**Timbers at Black Forest
Letter of Intent**

March 18, 2026

File No.: SF26XX

1. A final plat to allow for the creation of twenty-one single-family residential lots.
2. A finding of water sufficiency in terms of water quality, quantity, and dependability.

A PORTION OF THE SOUTHWEST QUARTER OF SECTION 22,
TOWNSHIP 12 SOUTH, RANGE 65 WEST OF THE 6TH P.M.,
COUNTY OF EL PASO, STATE OF COLORADO

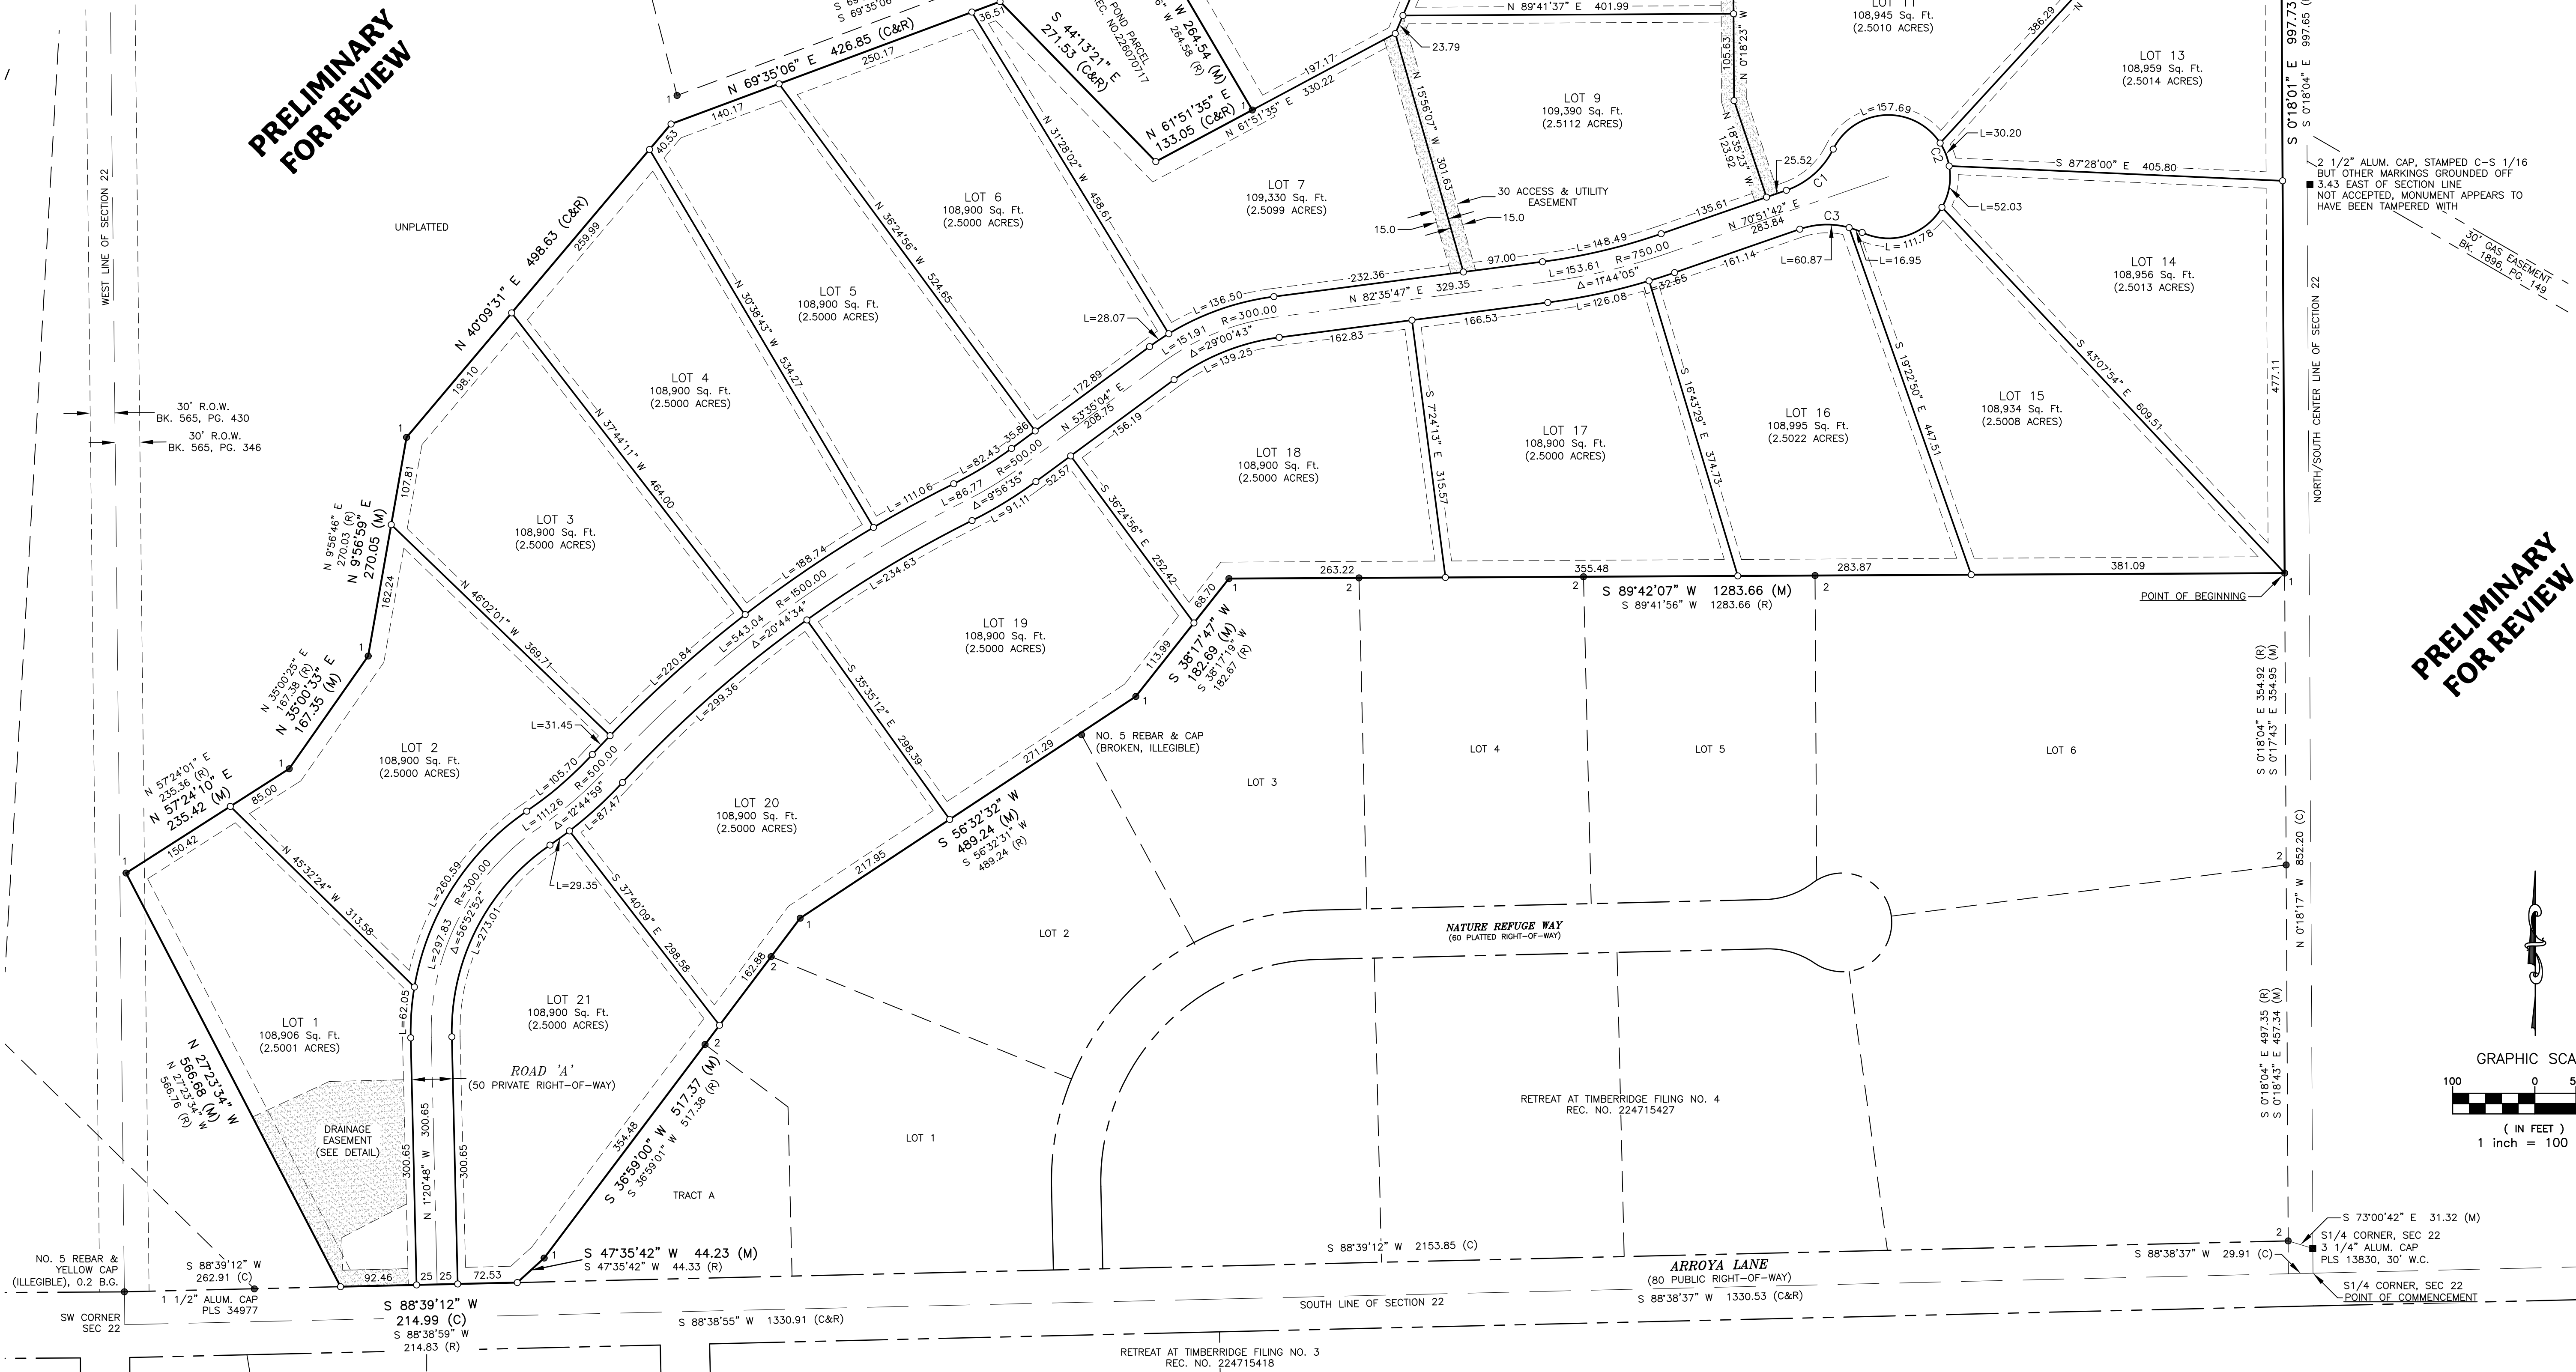
Multiple lots do not front a roadway, and may not meet 200' at setback requirement; lot 12 may need to be removed to meet standards for the other lots. Please review design standards in chapter 8.

Please include drainage easements mentioned on plat

Please include drainage easements mentioned on plat
